Your ref: 3/2022/1116
Our ref: DC/22/4342
Date: 23-JAN-23

Location: Land off Hawthorne Farm Hawthorne Place Clitheroe BB7 2HU
Proposal: Discharge of Condition 9 (Drainage Scheme) of planning application 3/2019/1104.

Further to our review of the submitted documents, Drawing 19310-EDGE-XX-XX-DR-C-C2008, Rev P11- Dated 21/04/22, United Utilities recommends that condition 9 is not discharged. This is because:

Project Name:
HAWTHORNE FARM CLITHEROE
 Client:
PERSIMMON HOMES
 Designed: **D.A.** Drawn: **D.A.** Checked: **R.A.** Scale: **1:250**
DRAINAGE LAYOUT
 Project No:
19310
 Drawing No:
19310-EDGE-XX-XX-DR-C-C2001 P18
PRELIMINARY NOT FOR CONSTRUCTION

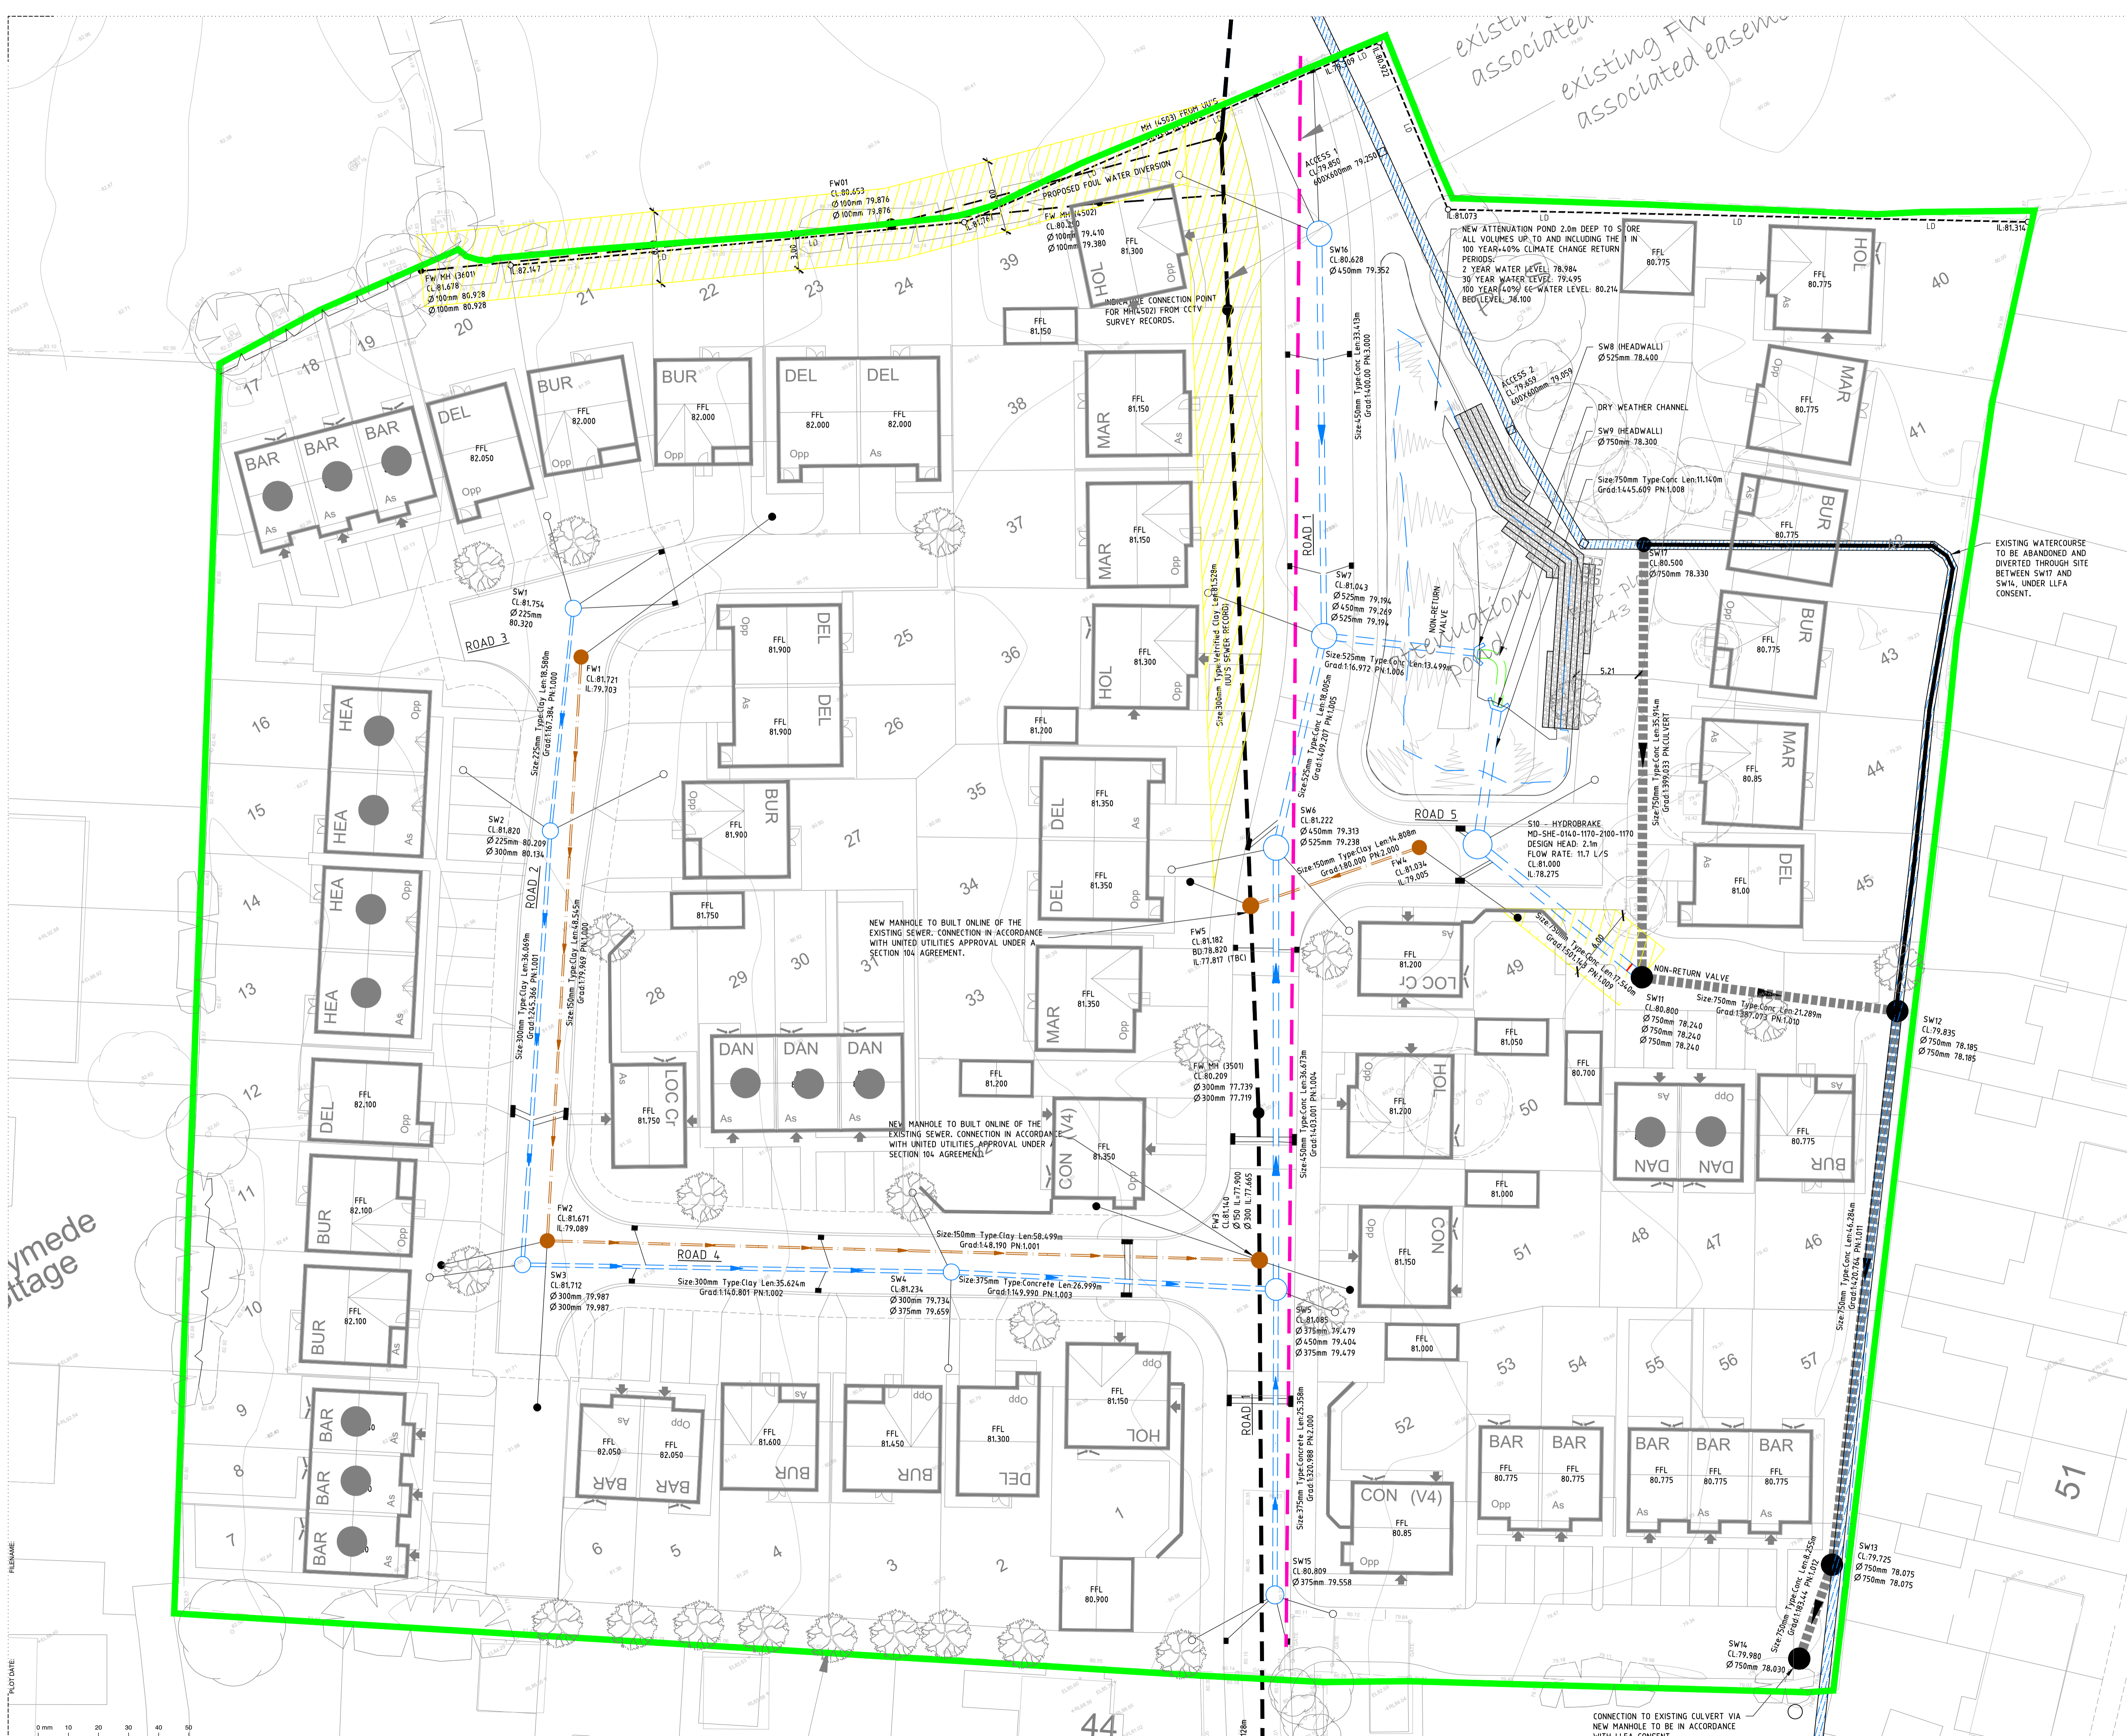
We notice that the proposal incorporates a SuDS component(s) which interacts with a sewer network that may be offered for adoption by United Utilities. We recommend the applicant seeks further advice regarding the SuDS design by visiting our website. See Contacts section below.

If the applicant intends to offer the site drainage forward for adoption to United Utilities, they should be aware that the proposals submitted within this application do not currently meet with our adoptions criteria. We recommend the applicant seeks further advice regarding the SuDS design by visiting our website. See Contacts section below.

We request that the applicant submits a plan outlining the proposed levels (including finished floor levels and ground levels) shown in metres above Ordnance Datum and an indicative foul and surface water drainage strategy (including cover and invert levels). It is our recommendation this information is submitted for our review so that any risk of sewer surcharge can be further assessed. The applicant should note that it may be necessary to raise finished floor and ground levels and / or include mitigation measures to manage the risk of sewer surcharge.

We request that the consideration of ground levels should assess whether the proposed development will create a new exceedance path onto the application site from the adjacent road and how this can be managed in the detail of the design for the site.

For the avoidance of doubt no surface water will be permitted to drain directly or indirectly into the public sewer.

The culverted watercourse that crosses the site is not a United Utilities asset and contact should be made with the Riparian owner who is responsible for the watercourse.
